Our Ref: F2012/00357

MUSIC FESTIVAL, ROYAL RANDWICK RACECOURSE (SSD 5394-2012)

I refer to your letter dated 12 November 2012 inviting Council to comment on the above-mentioned proposal for the Future Music Festival at the Royal Randwick Racecourse.

FIGURE 3 – PROPOSED EVENT LAYOUT

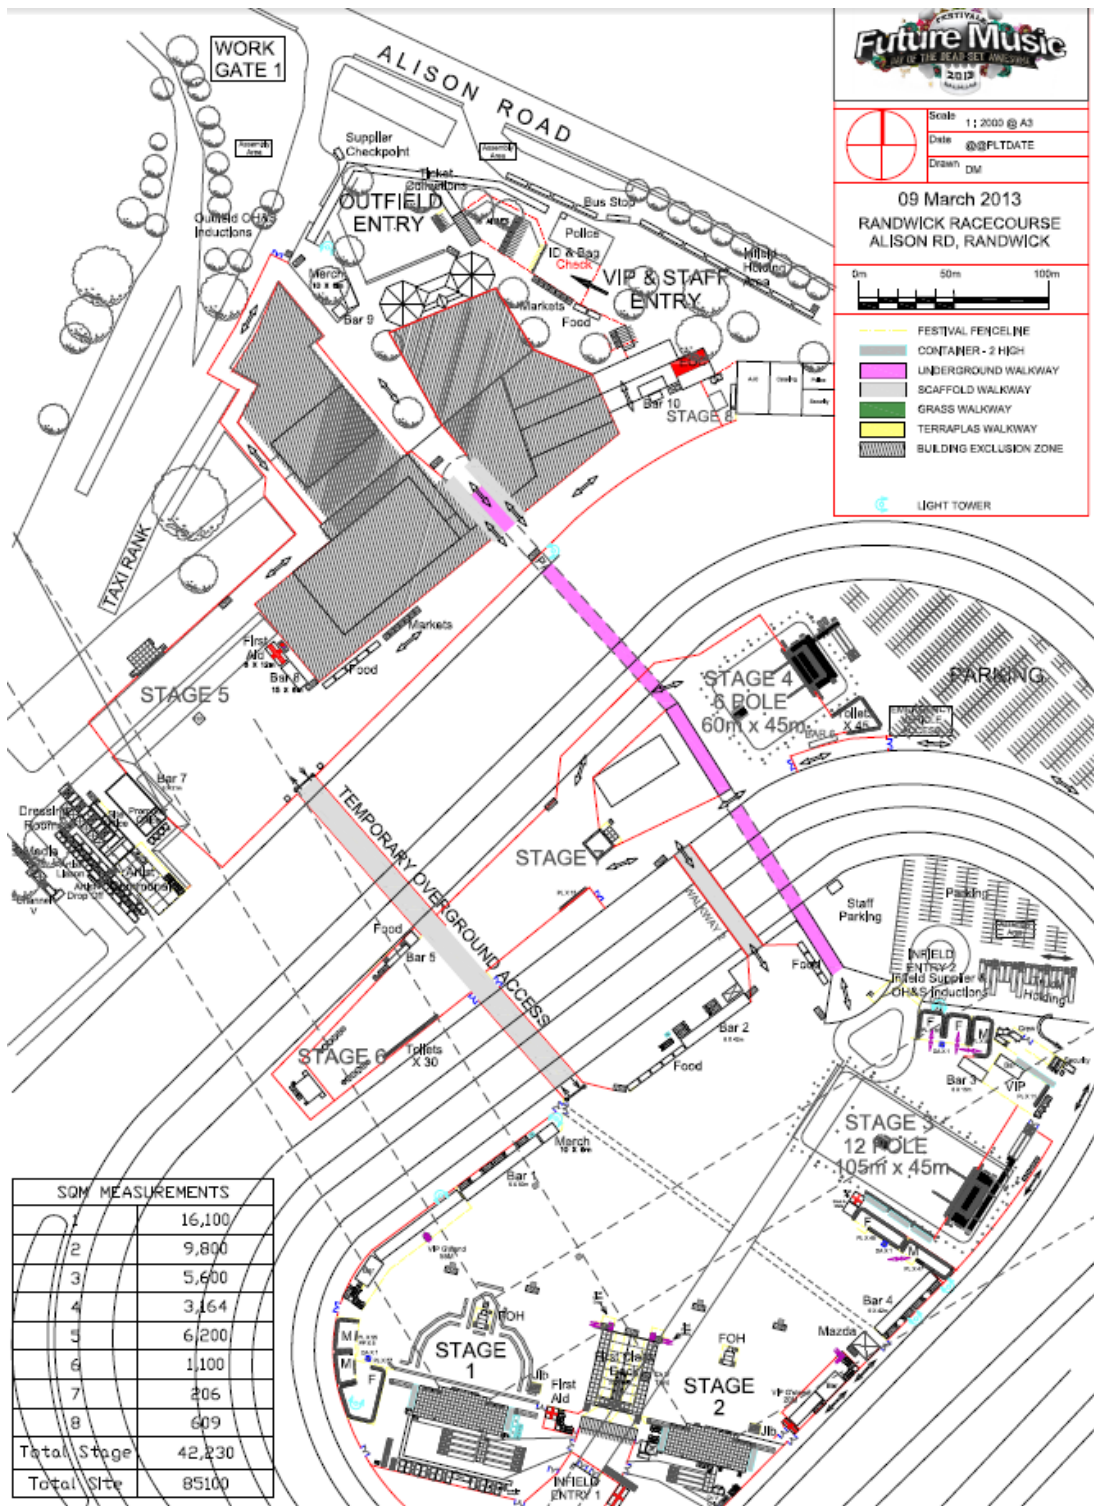
The event is to be held within the "Spectator Precinct" and "Midfield/Infield" areas of the site. The Midfield/Infield is in the centre of the tracks themselves. The Spectator Precinct is bounded by Alison Road, the former tramway/busway reserve and the track itself. This area includes the Members' Stand, as well as the Totaliser Building and the Tea House. It is noted, however, that this proposal nominates the Members' Stand and the Totaliser Building as part of a building exclusion zone, which is to be separated from the rest of the event areas by fencing to prevent access by patrons to areas where building works are taking place.

The event areas (Zones 1 through to 7) will also be divided from the remainder of the site by temporary fencing, with a temporary overground access between them, across the tracks, as well as the existing underground access. It is also noted that the EIS sets out the requirements of the proposed event including installation of stages, enclosures, decking, fencing, signage, toilets, lighting, rides and vending outlets. It appears that the event is to utilise existing toilet and bar facilities with additional temporary toilet and bar facilities and food vans brought onto the site. It is noted that the staging of the event does not involve the carrying out of any works within the site. Accordingly, while the proposed event will not likely impact upon the heritage significance of the Racecourse site, the following conditions should be included in any consent:

- The installation of temporary facilities including stages, enclosures, decking, fencing, signage, toilets, lighting, rides and vending outlets is to be carried out to ensure that there is no damage to the site, including built structures and landscape elements.
- Any damage to the site, including built structures and landscape elements is to be made good to its previous condition by the applicant.

FIGURE 4 – EXTENT OF WASTE MANAGEMENT

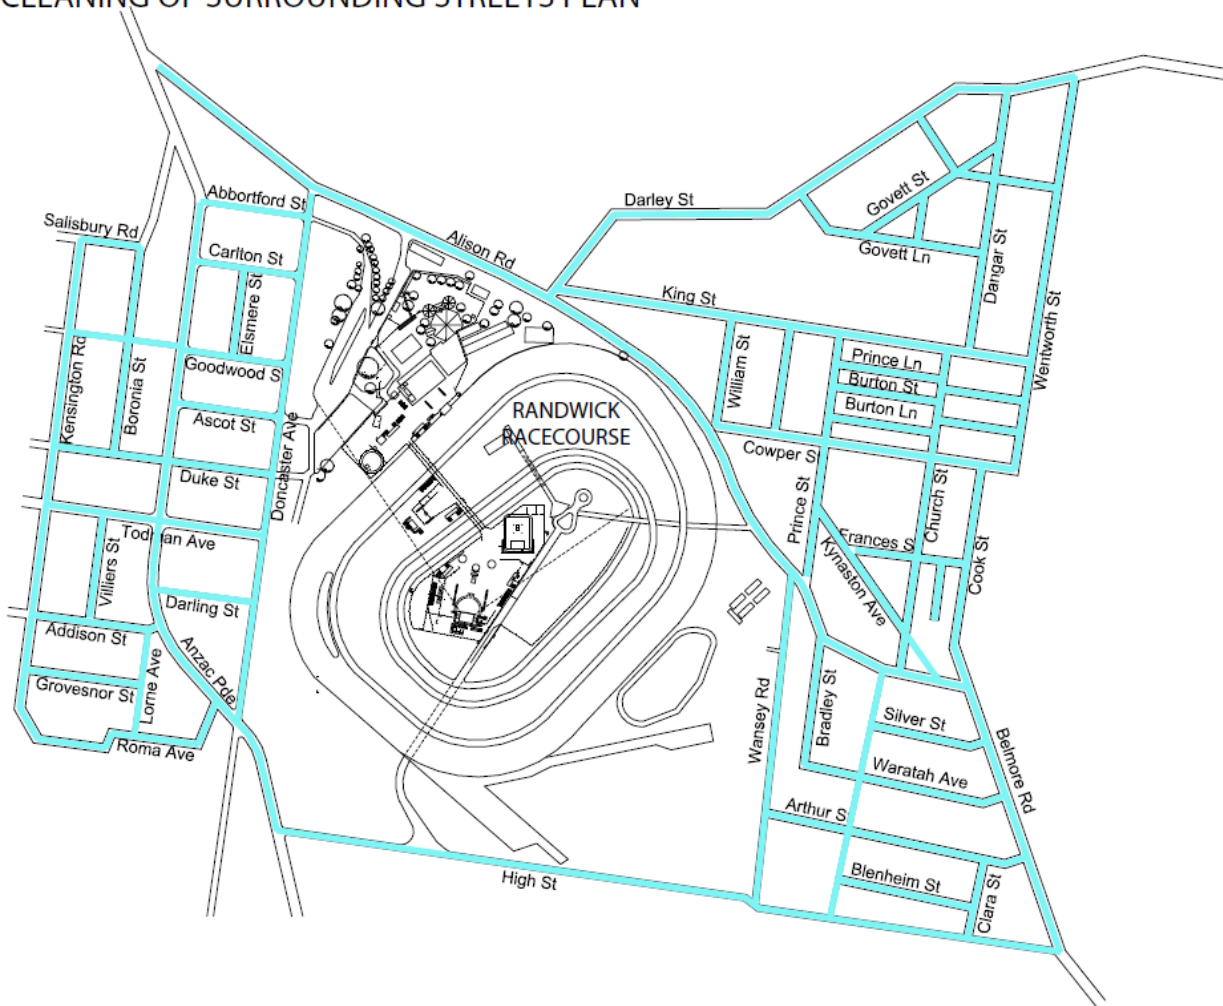
34. The applicant is to thoroughly clean the surrounding area within 24 hours of the termination of the event. This is to include the area bounded by Anzac

Parade, Boronia Street, Salisbury Road, Kensington Road, Roma Avenue, High Street, Botany Street, Cook Street, Cowper Street, Wentworth Street, Darley Road and Alison Road.
